TfNSW Reference: SYD15/01390/29
Departments Reference: SSD 7348 MOD 6

SECTION 4.55 (1A) MODIFICATION TO APPROVED OAKDALE WEST ESTATE - WAREHOUSE & DISTRIBUTION FACILITY - ERSKINE PARK

Precinct Area Schedule		
Precinct 1		29.61 ha
Net Developable area		21.80 ha
Precinct 2		31.86 ha
Net Developable area		26.69 ha
Precinct 3		17.51 ha
Net Developable area		11.10 ha
Precinct 4		22.76 ha
Net Developable area		22.11 ha
Precinct 5		13.45 ha
Net Developable area		6.01 ha

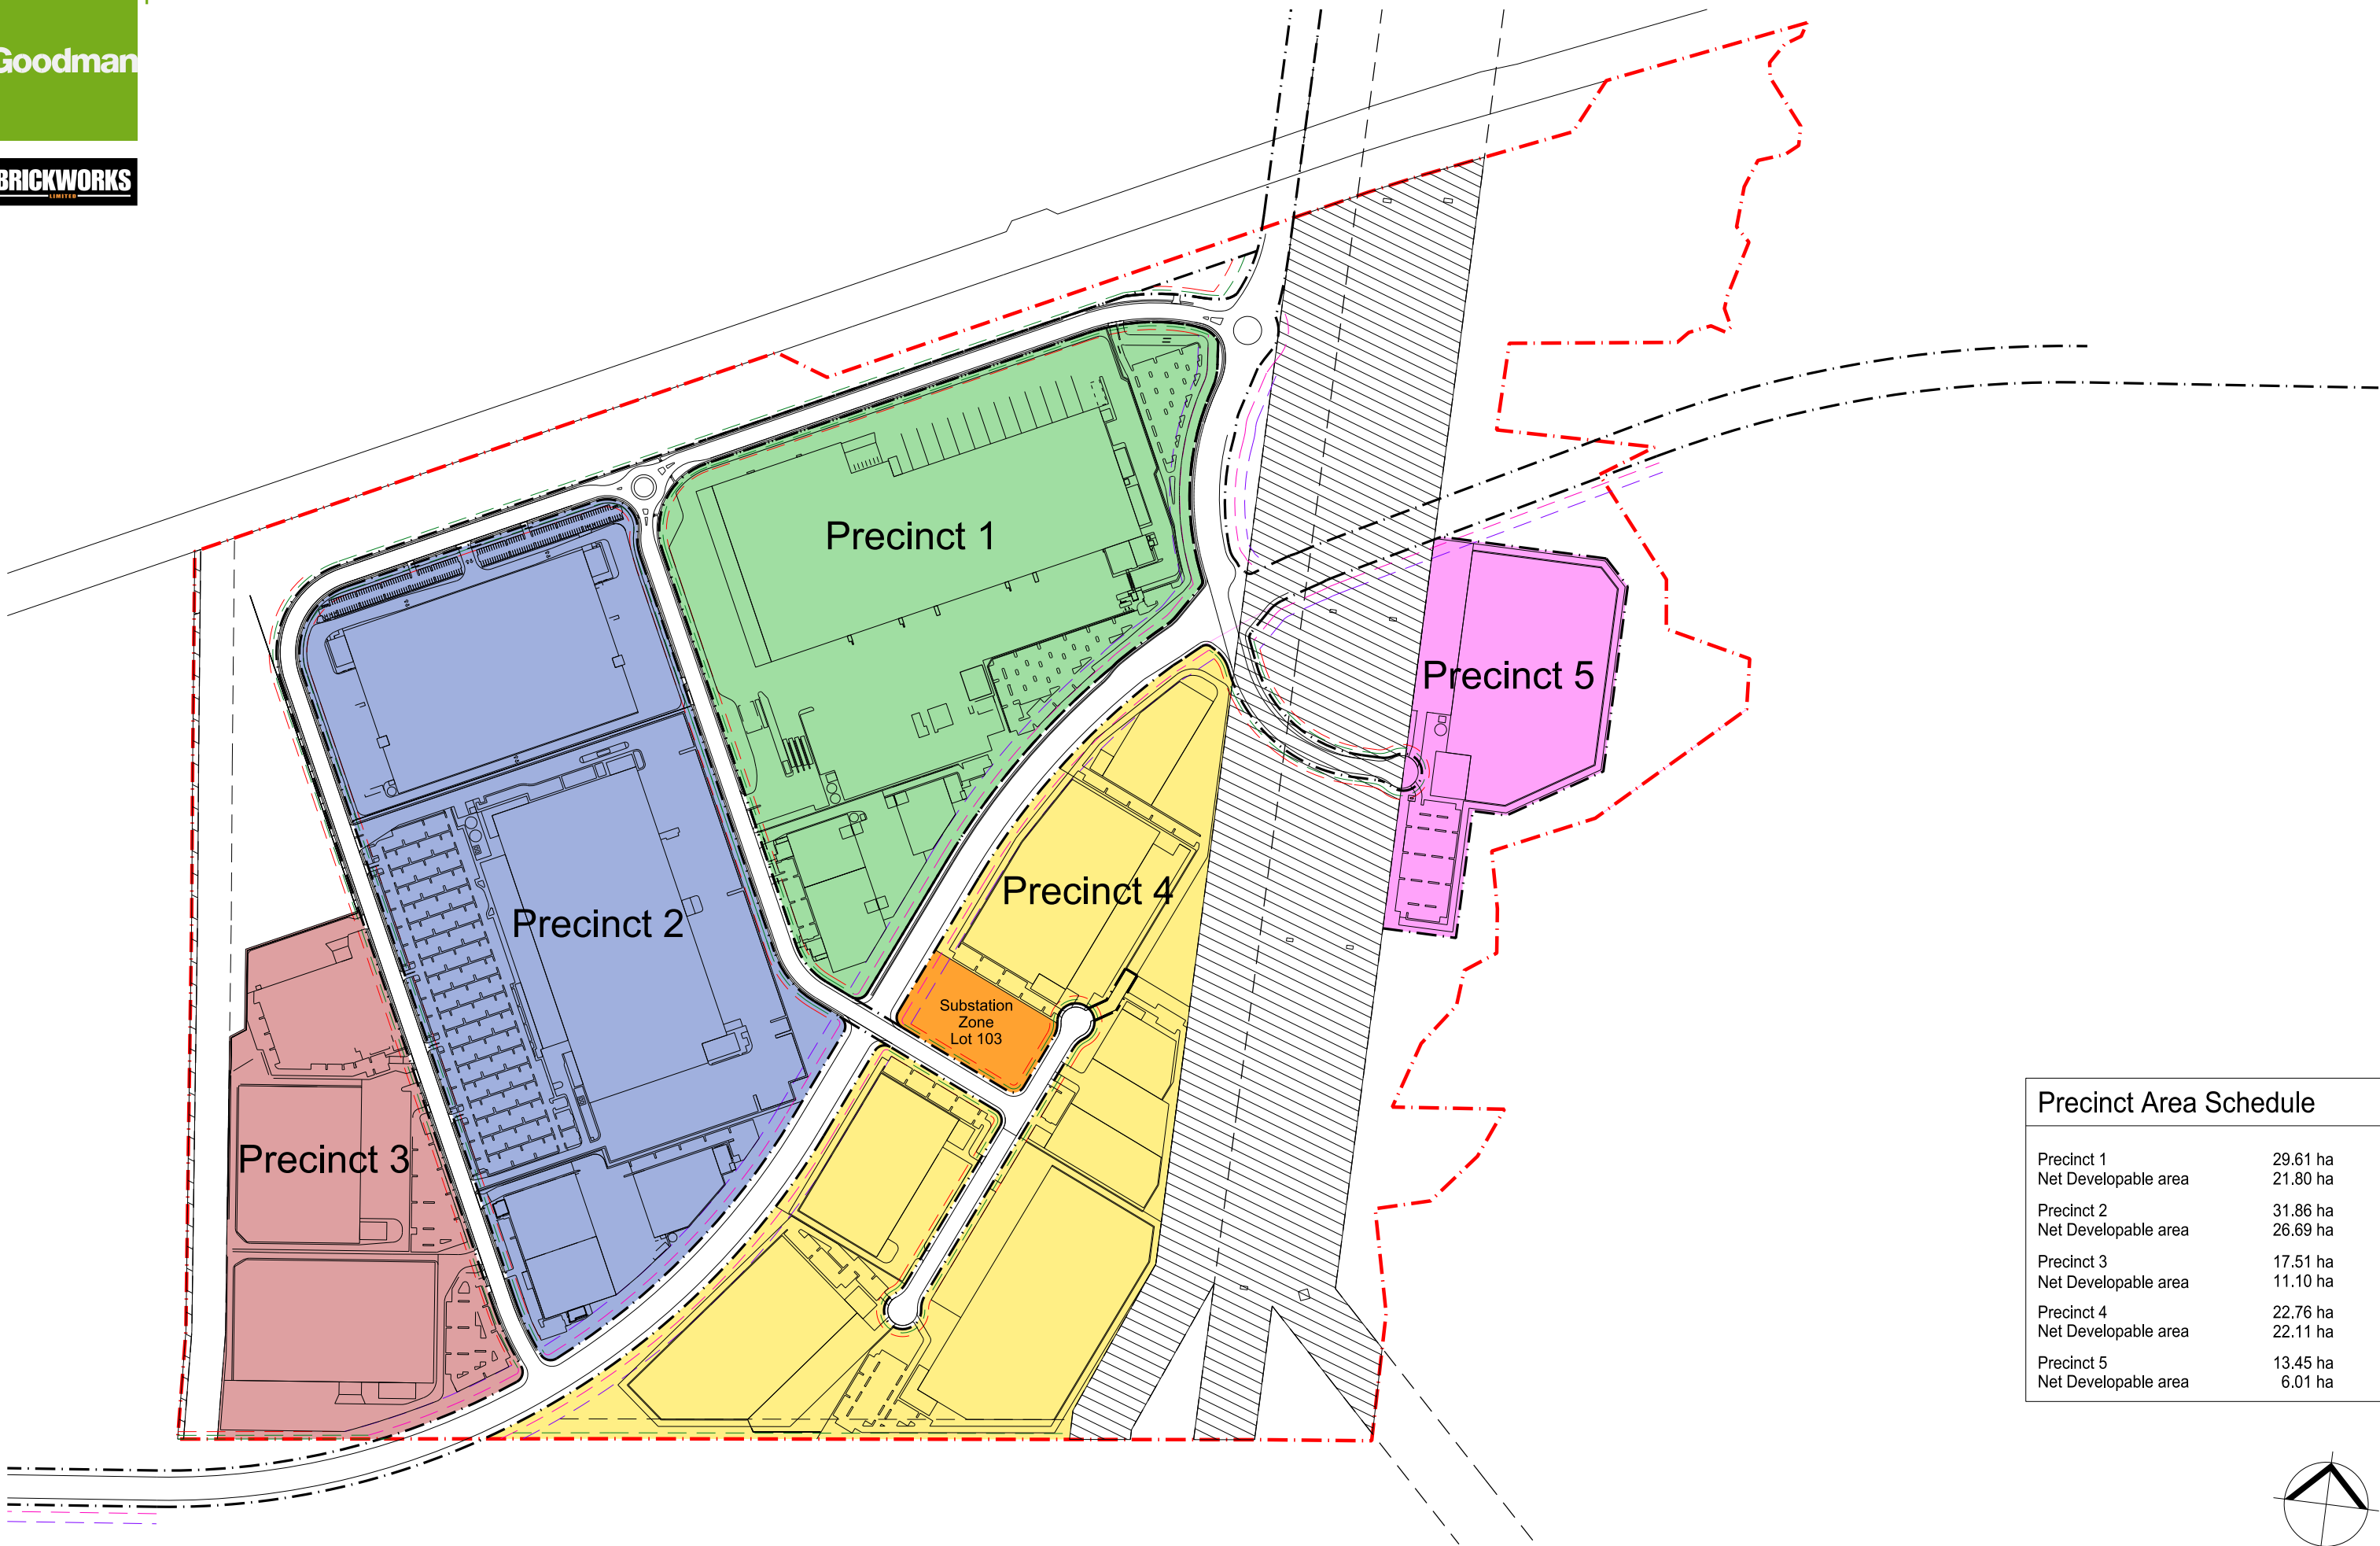
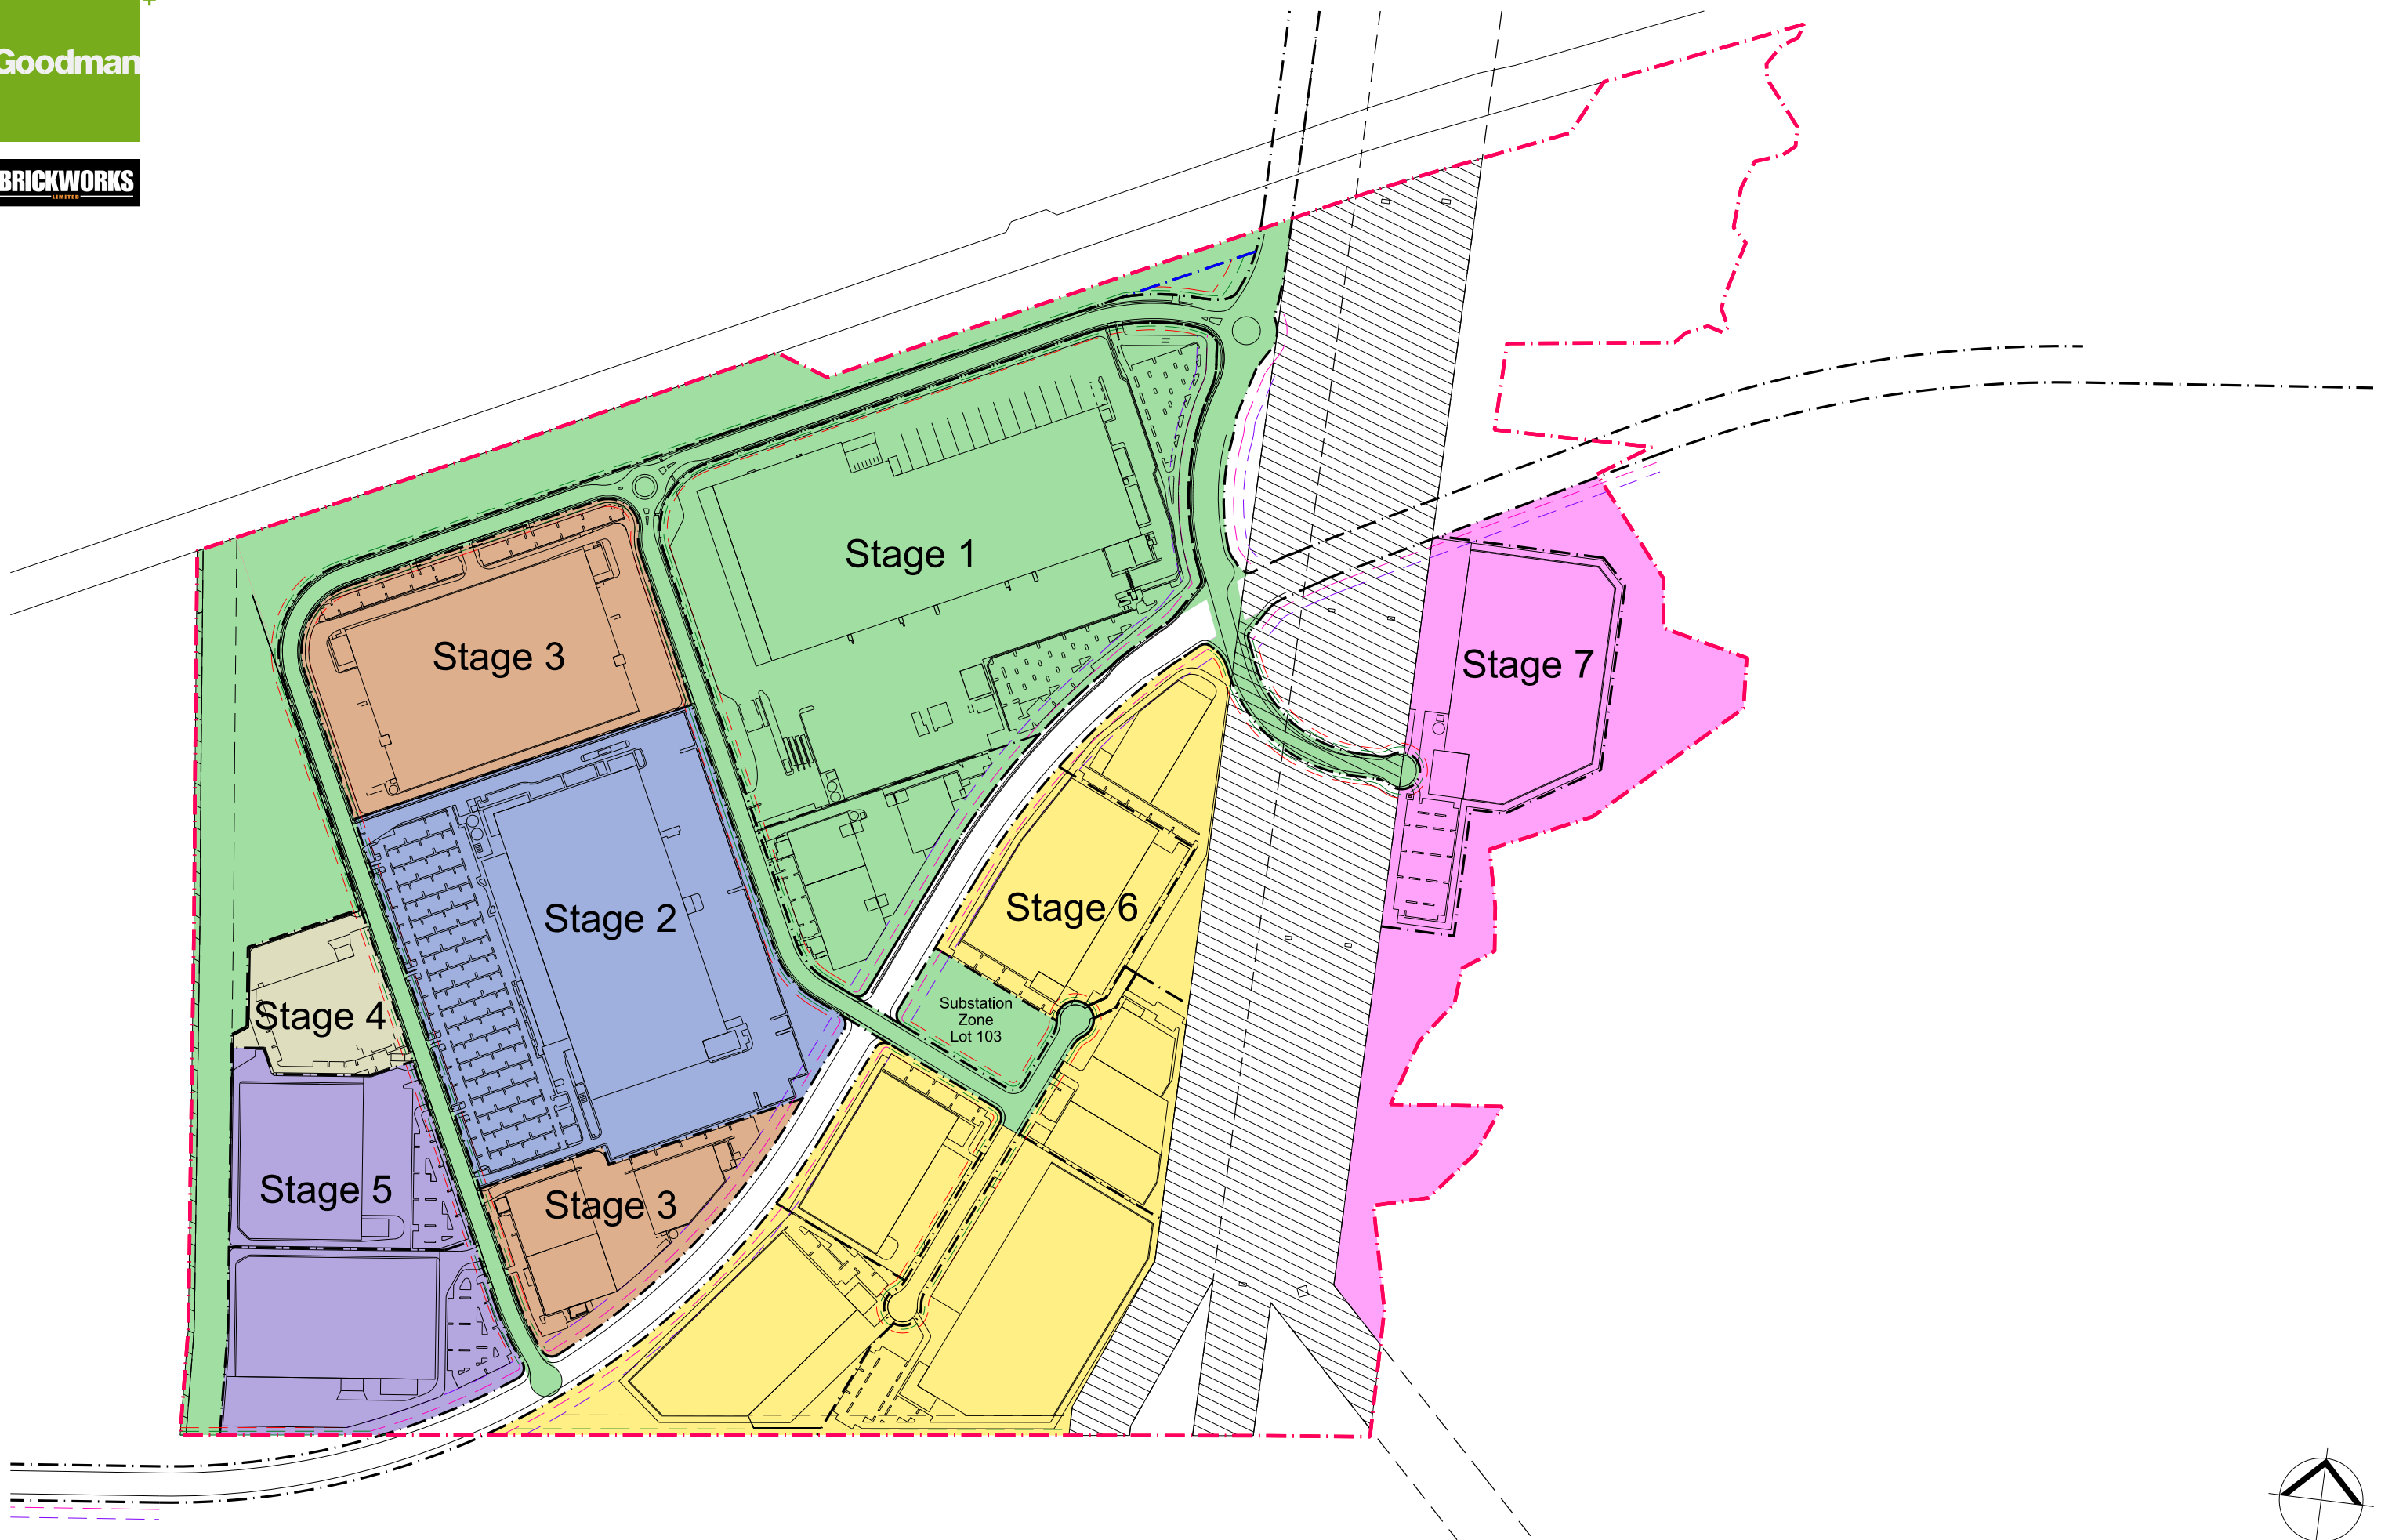
The lack of clear marking or labelling of the Gazetted Western Sydney Freight Line (WSFL) as SP2 on the maps makes it difficult to identify the impact on the proposed WSFL corridor.

TfNSW requests the maps be updated to identify the Gazetted Western Sydney Freight Lines as SP2 for clarity.
